Tel: 01903 737756
Email: planning@arun.gov.uk
www.arun.gov.uk/planning
Please ask for: Laura Mills
Email: laura.mills@arun.gov.uk
Telephone: 01903737794
Our Ref: BR/171/26/PL
Your Ref:
Date: 29th September 2026

Application for Planning Permission

Development: Proposed single storey flat roof extension to the rear of exsisting AGC, including installation of external associated a/c plant and smoking shelter to existing yard area.

Location: 32 London Road Bognor Regis PO21 1PY

SCALES 1:50 @ A1	CHECKED
SHEET NUMBER 3635(B)02	
REVISION	
DATE 30/09/2026	DRAWN S.STEEL

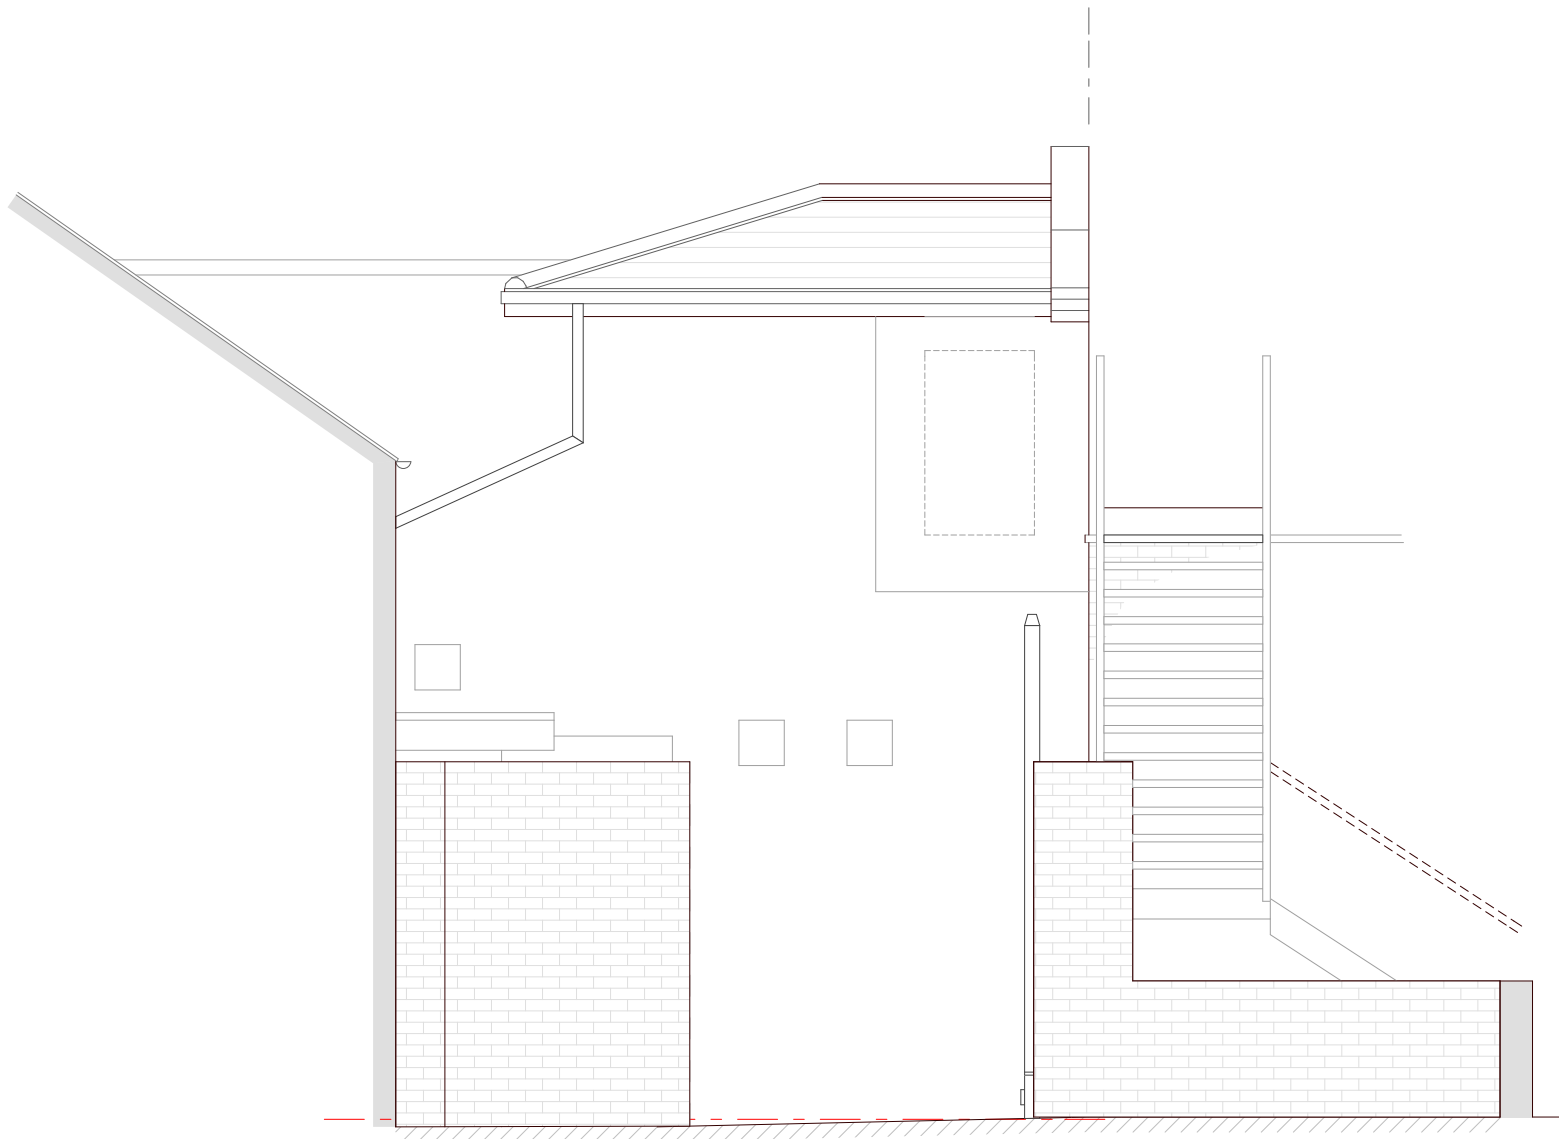
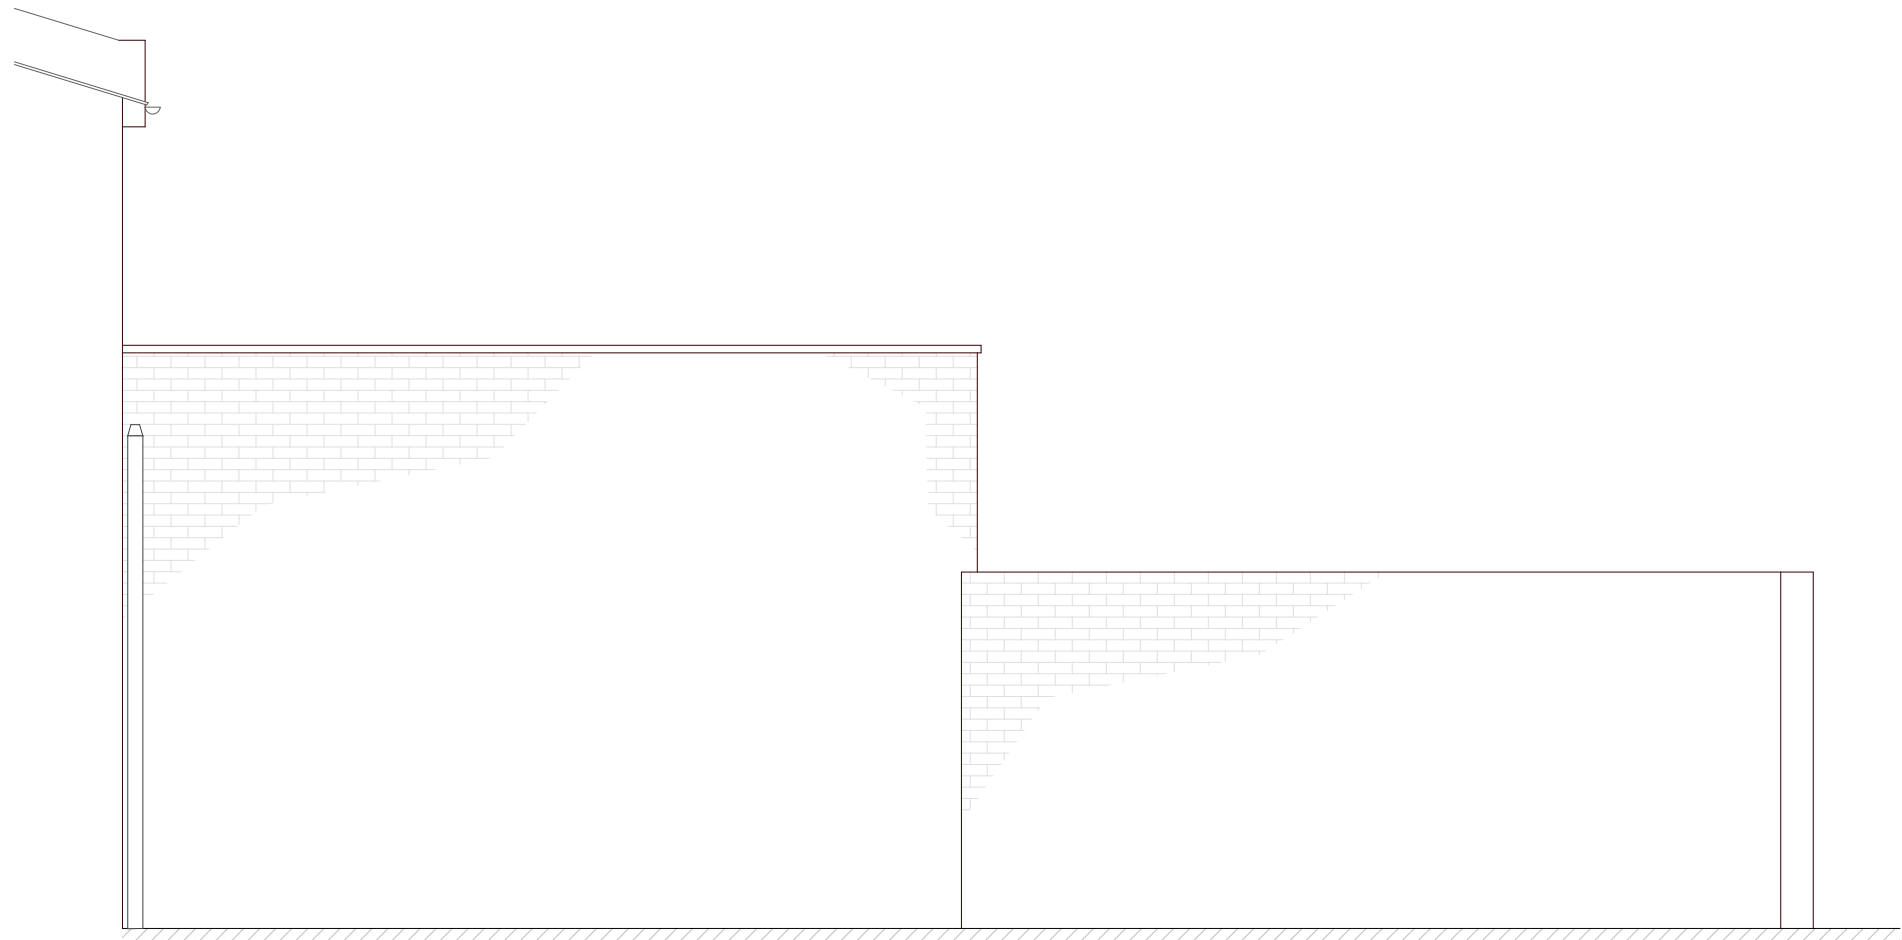
Existing Elevations Sheet no. 3635(B)02

There appear to be 2 x 'West' labels, please amend to show 'East' and 'West'

SHEET NUMBER
3635(C)02

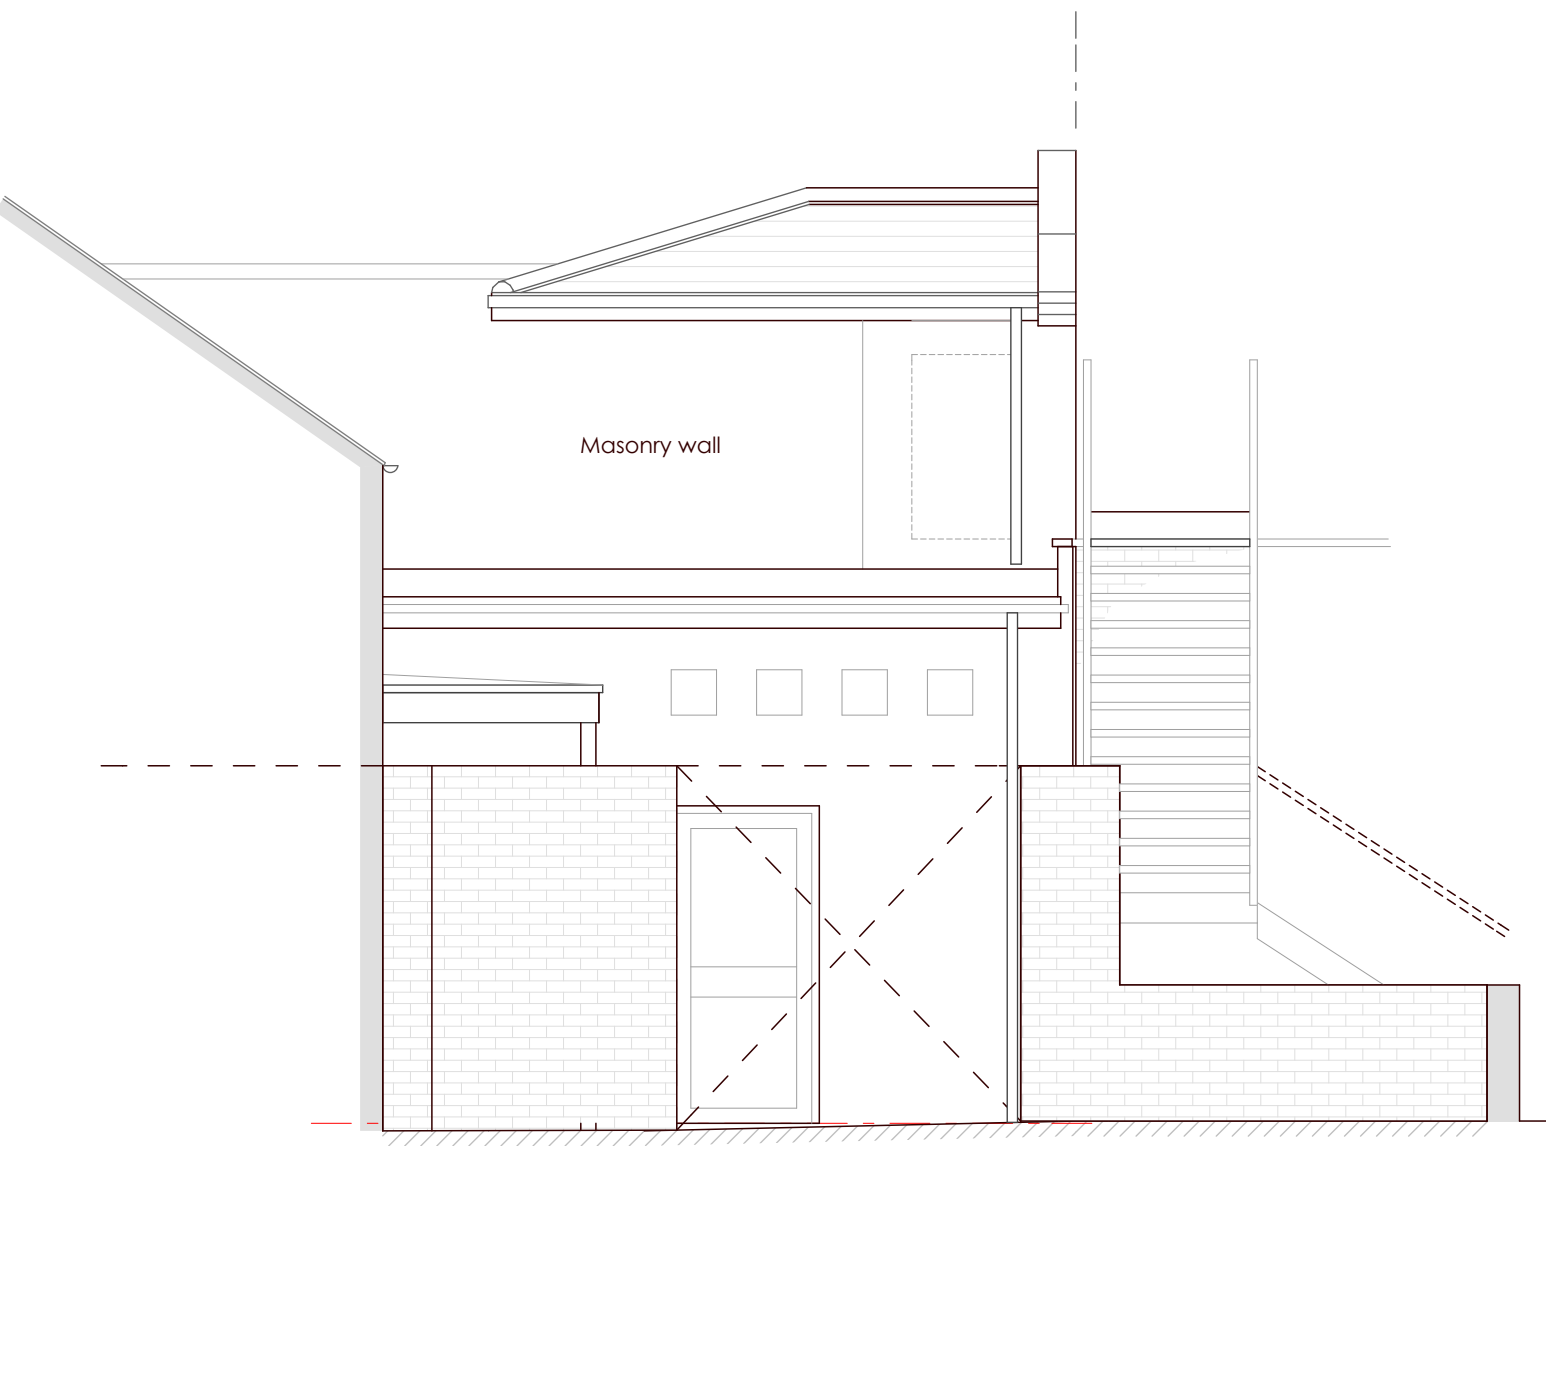
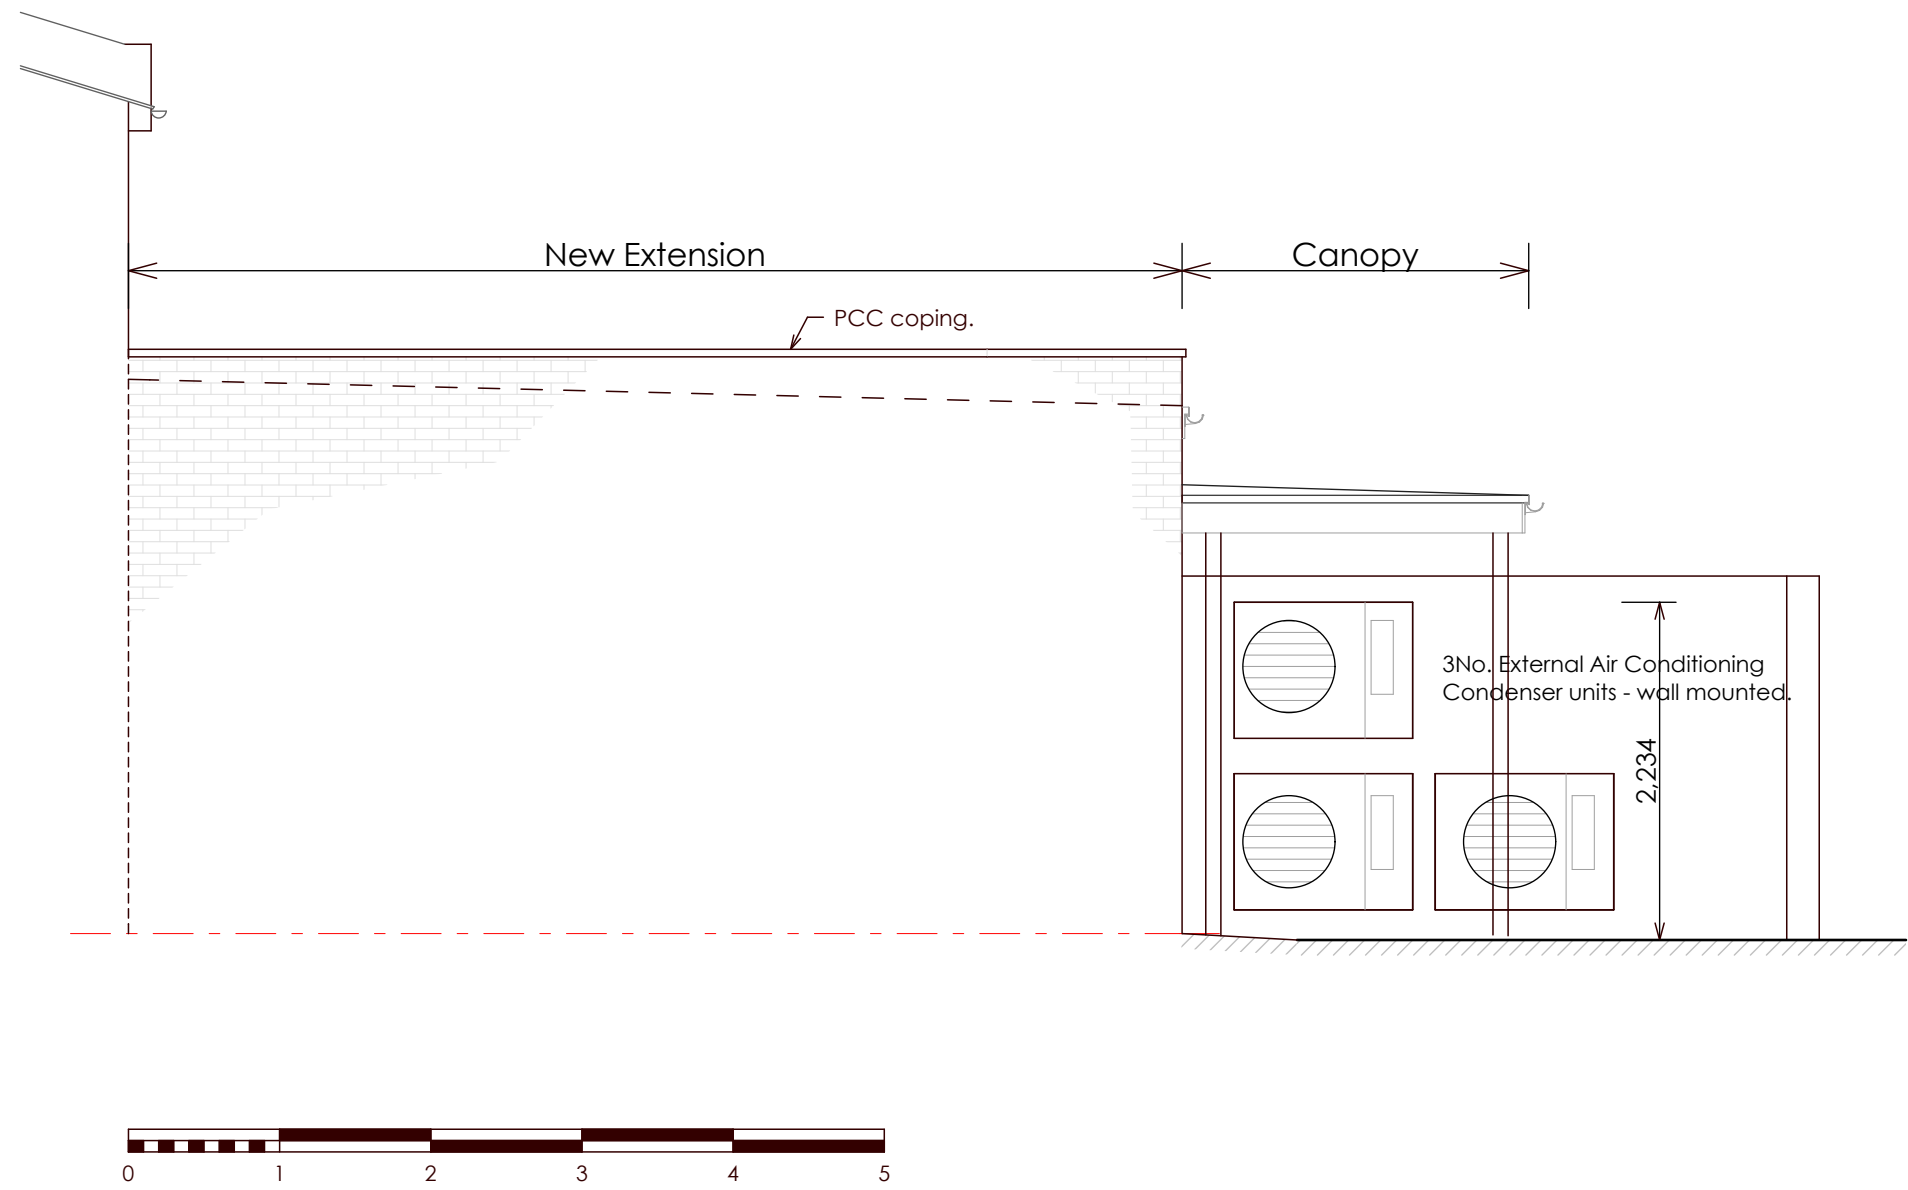
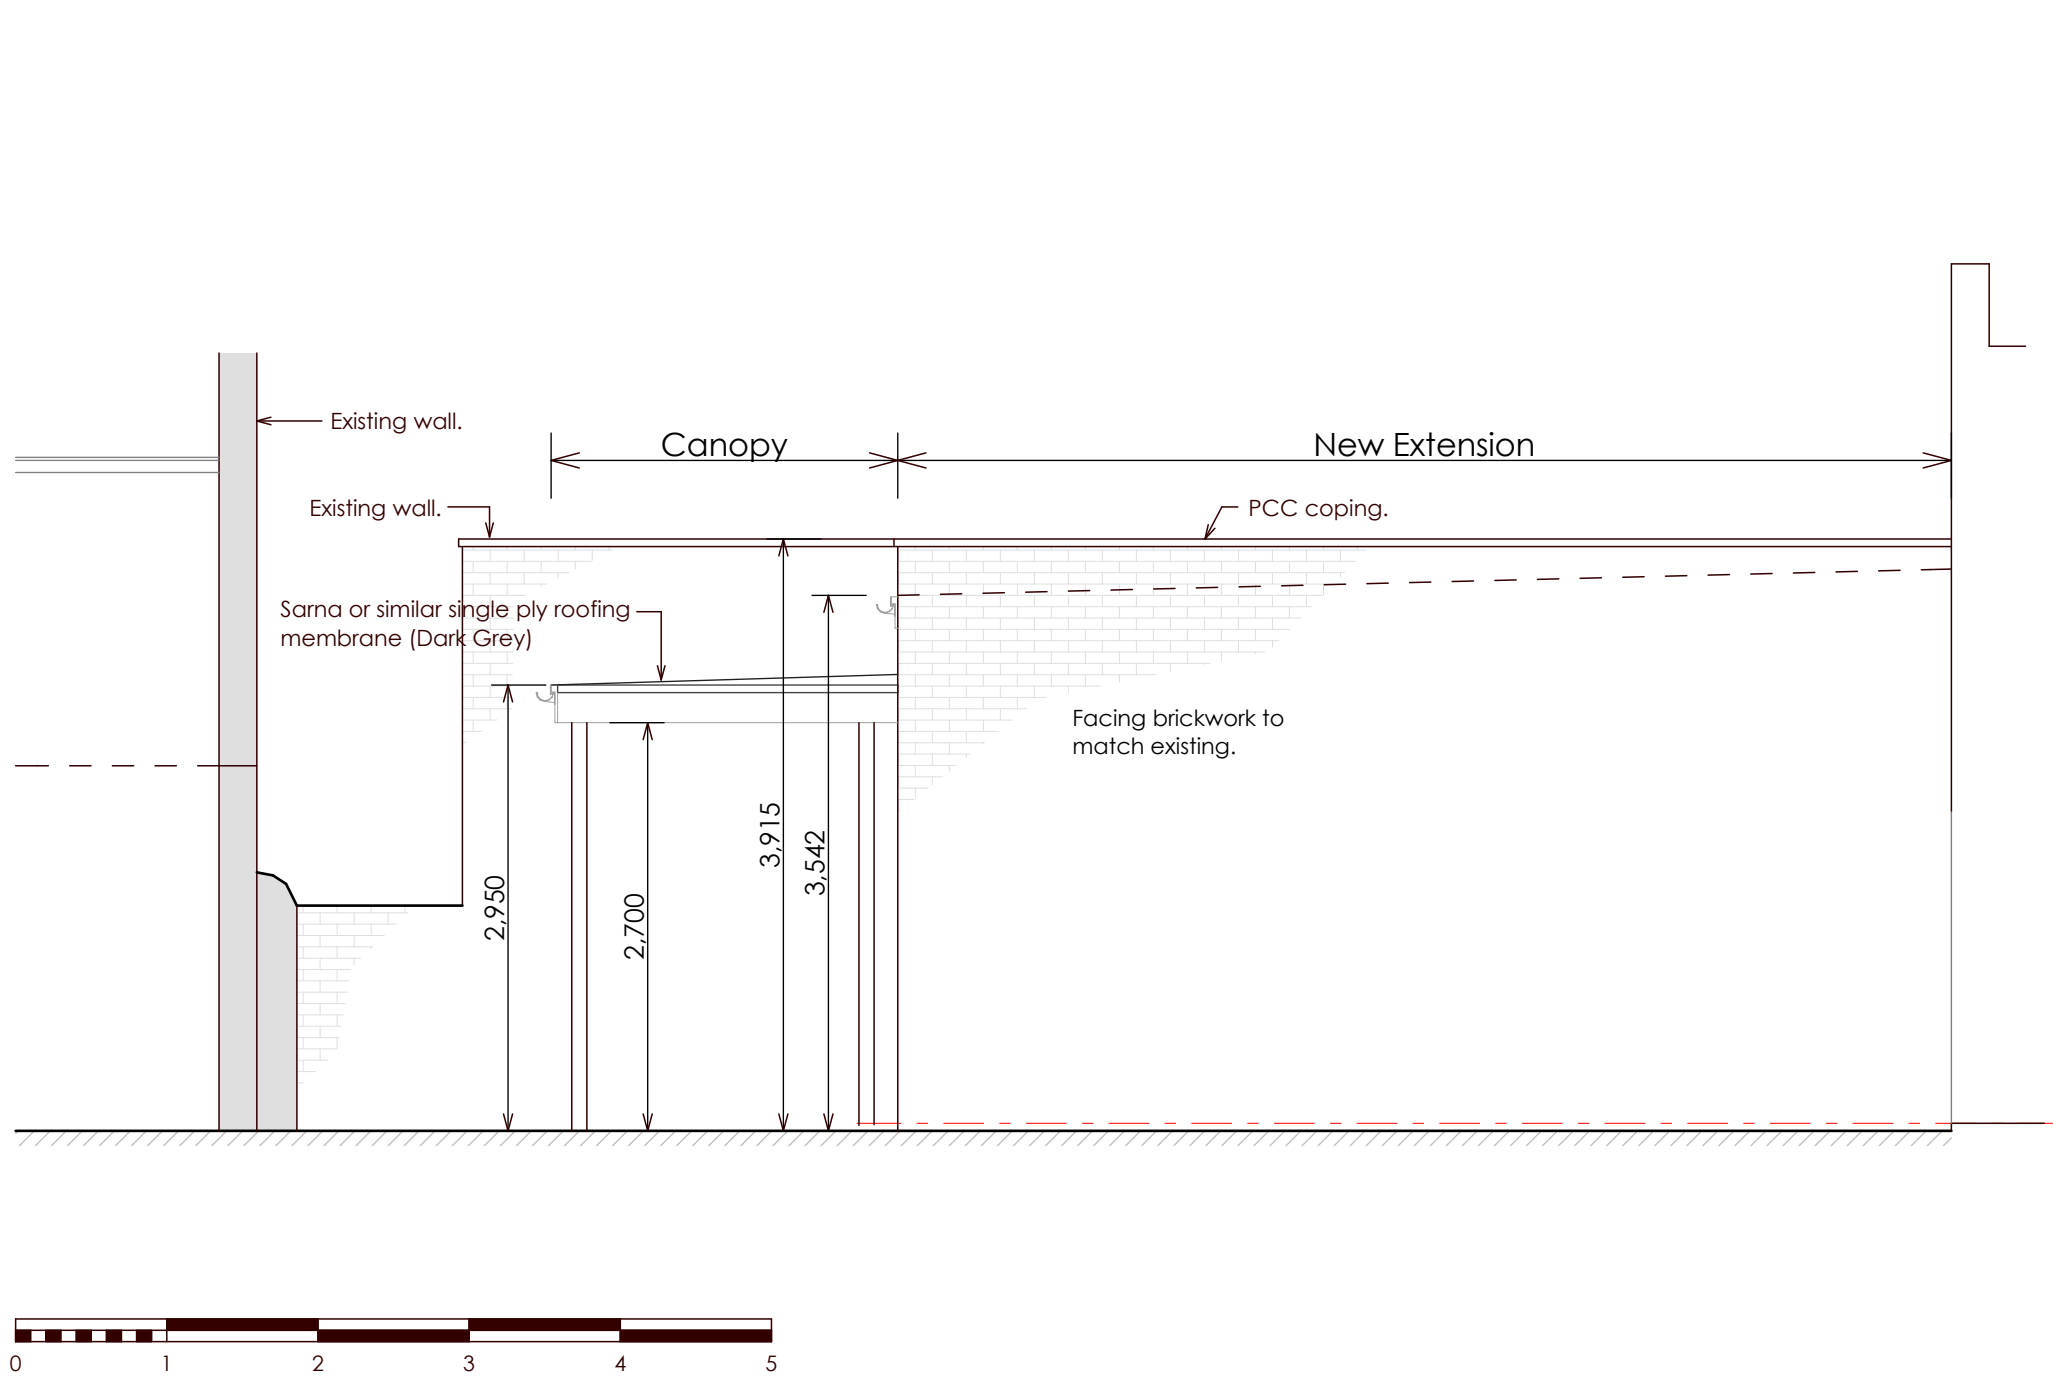
Proposed Elevations Sheet no. 3635(C)02

There appear to be 2 x 'West' labels, please amend to show 'East' and 'West'

The condensing units are not scaling at 1:50 please amend to show correct scale.
